**Heyford Park, Camp Road, Upper Heyford,  
Bicester, OX25 5HD**

**23/01959/NMA**

**Proposal:** Non-material amendment to 16/02446/F - amended elevation plans for 7 plots (plots 630-632, 634-635 & 646-647)

**REAR ELEVATION**

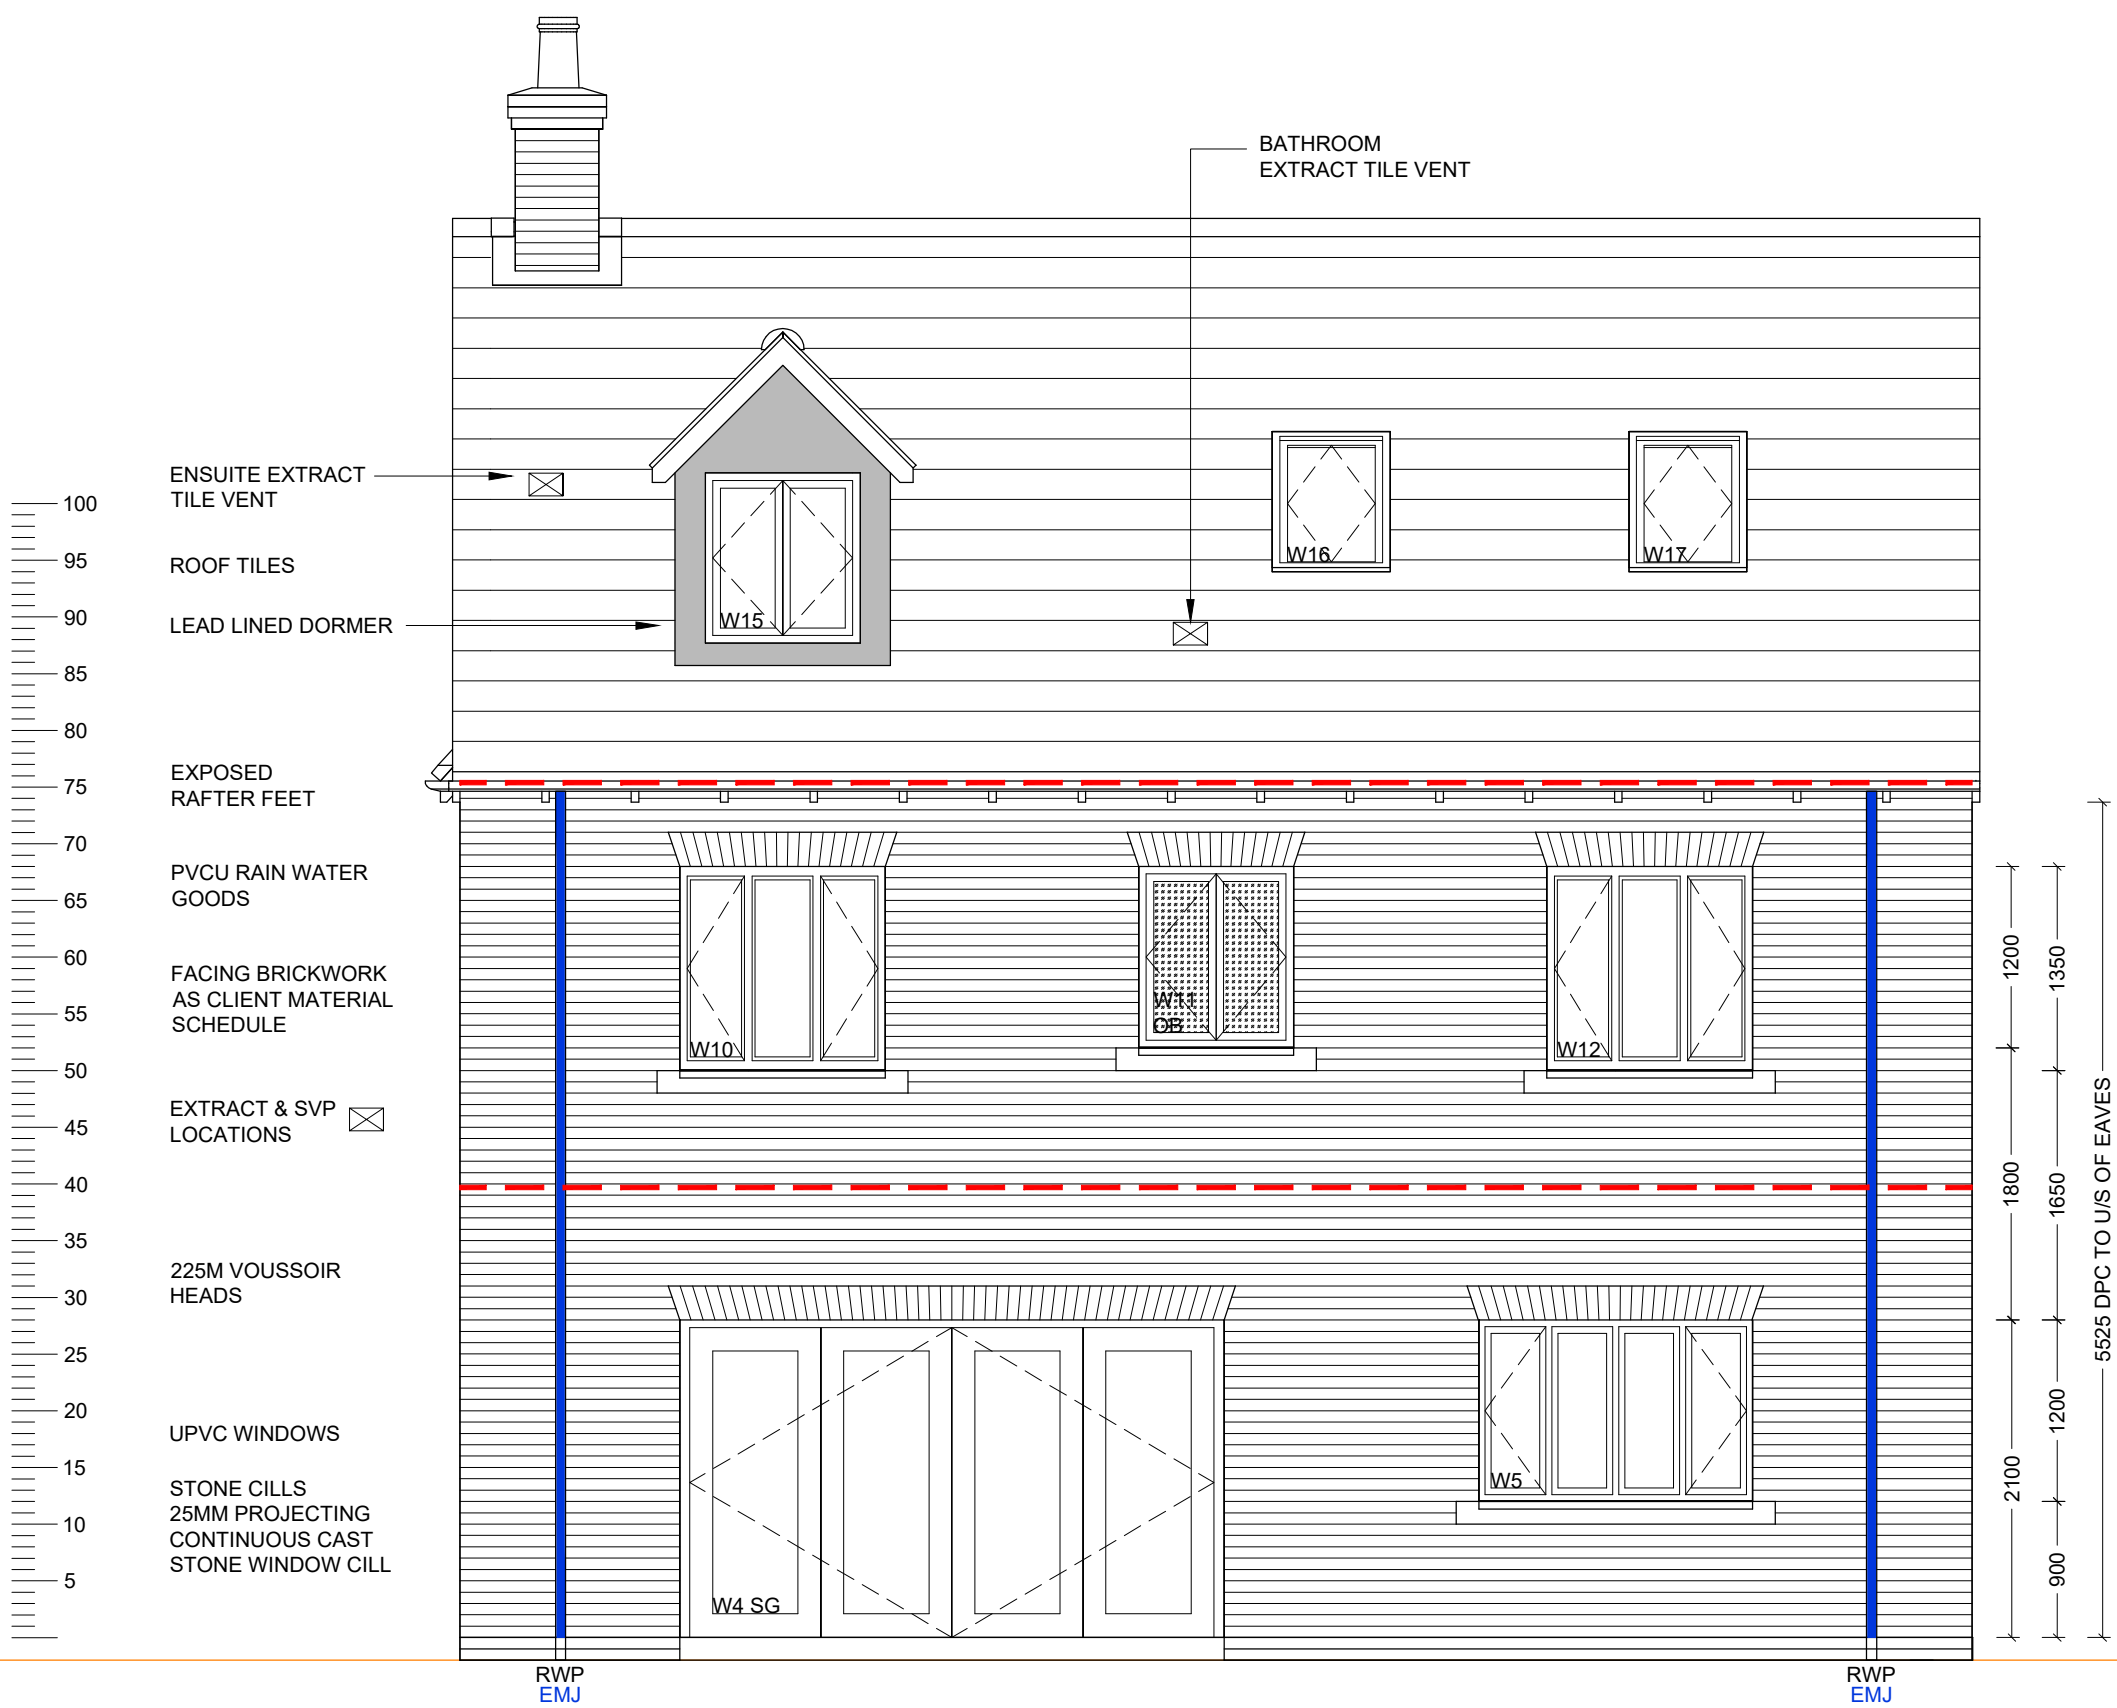
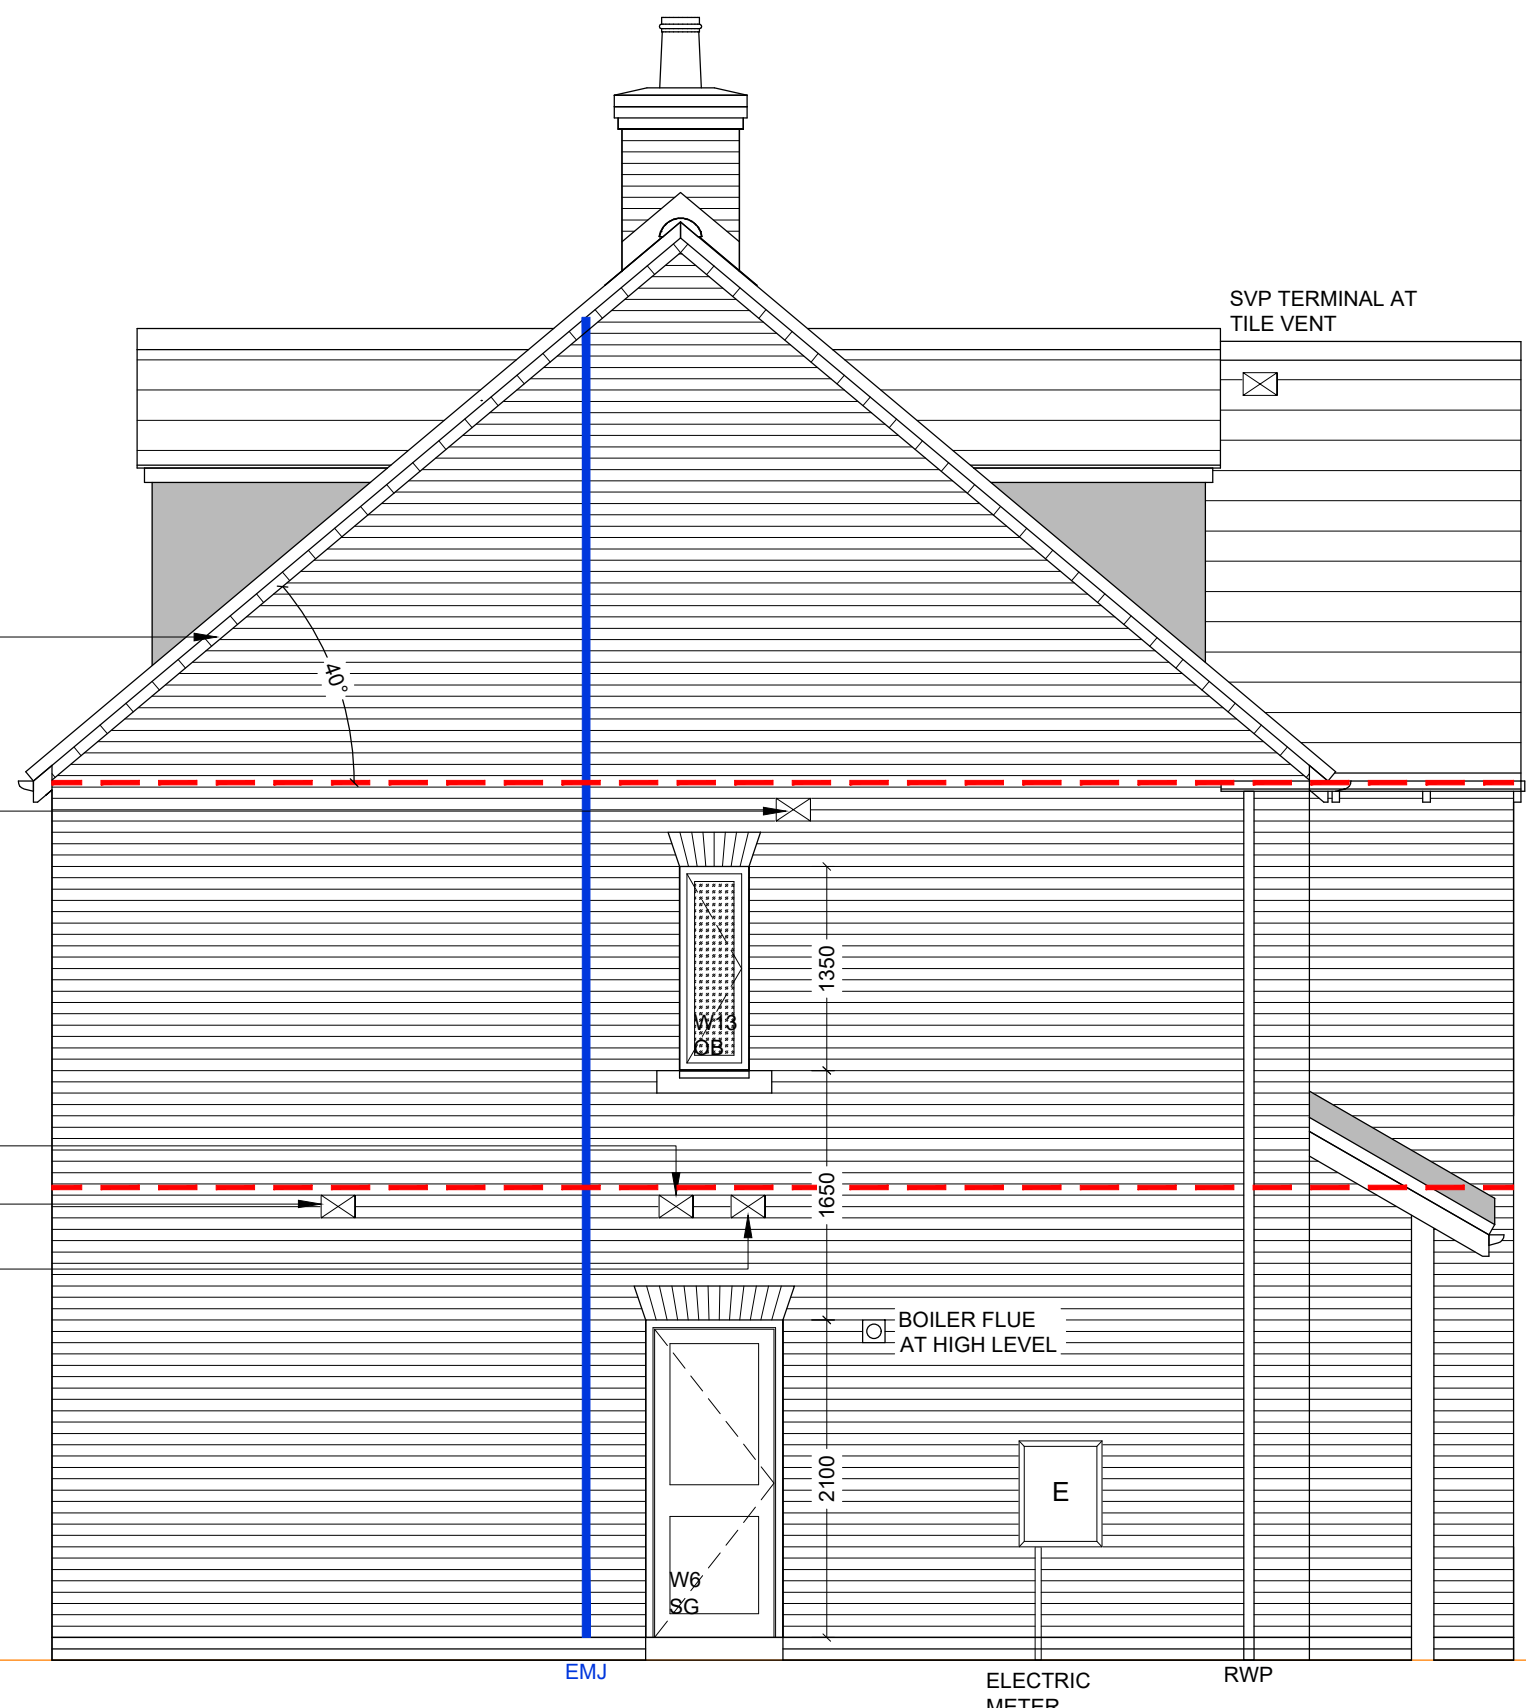
#### House Type 4A – Plot no.632

- Both render and brick elevations have stone surrounds added;
- Brick elevations have quoin detail added to front elevation corners;
- Render elevations have additional brick detailing to gable ends;
- 1st floor windows elongated.
